PROJECT NAME: Longfellow School PTO Shed

PROJECT ADDRESS: 432 Stevens Ave CHART/BLOCK/LOT: 175-B-2

PROJECT DESCRIPTION: (Please Attach Sketch/Plan of the Proposal/Development)
Wooden Storage Shed 8' x 14' x 9'

LONGFELLOW ELEMENTARY  
PTO STORAGE SHED  
JULY 25 2013

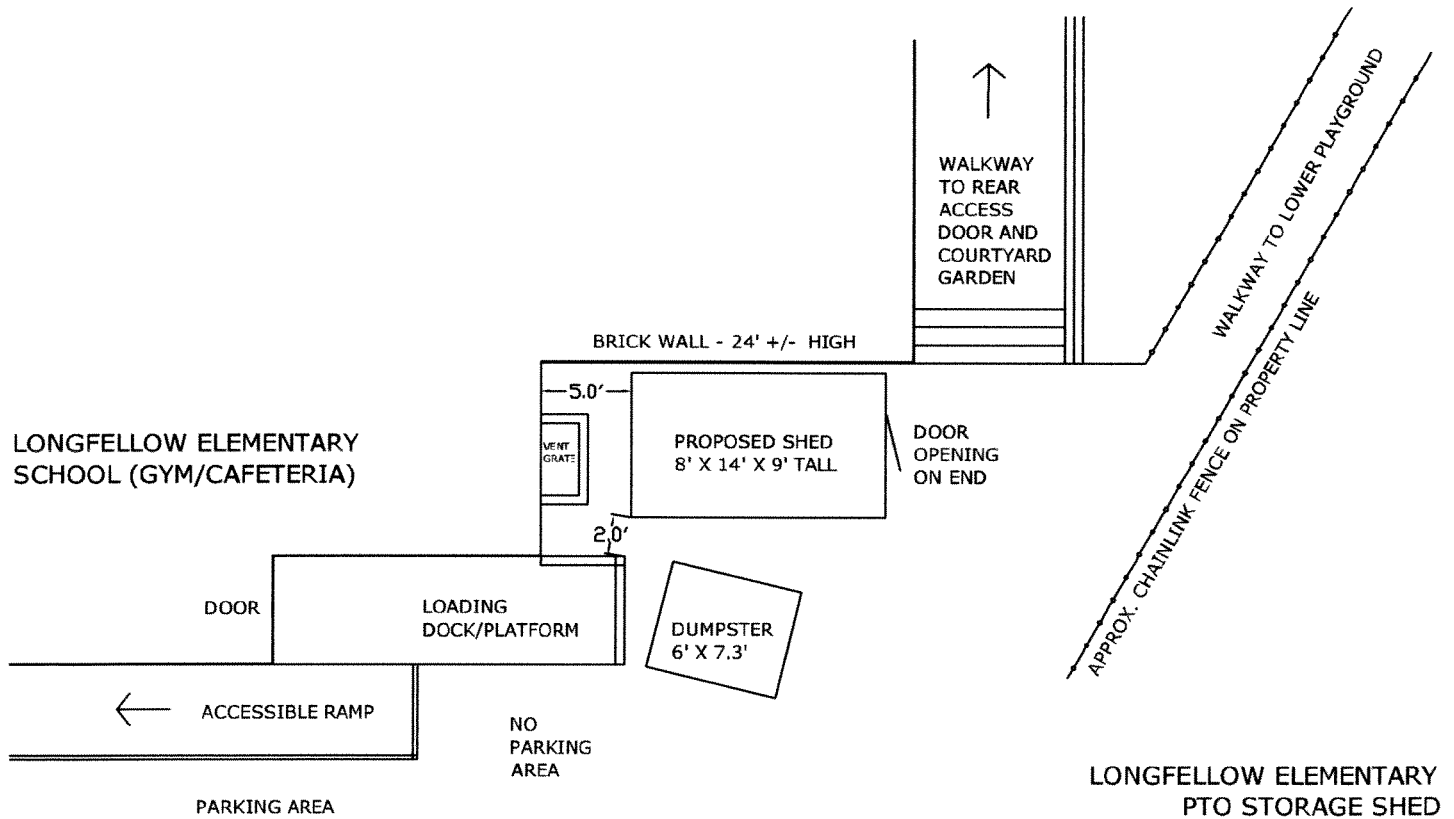
* Request shed ^{back} be placed against bldg to permit access to ramp & back stairs to courtyard, as well as dumpster spacing.
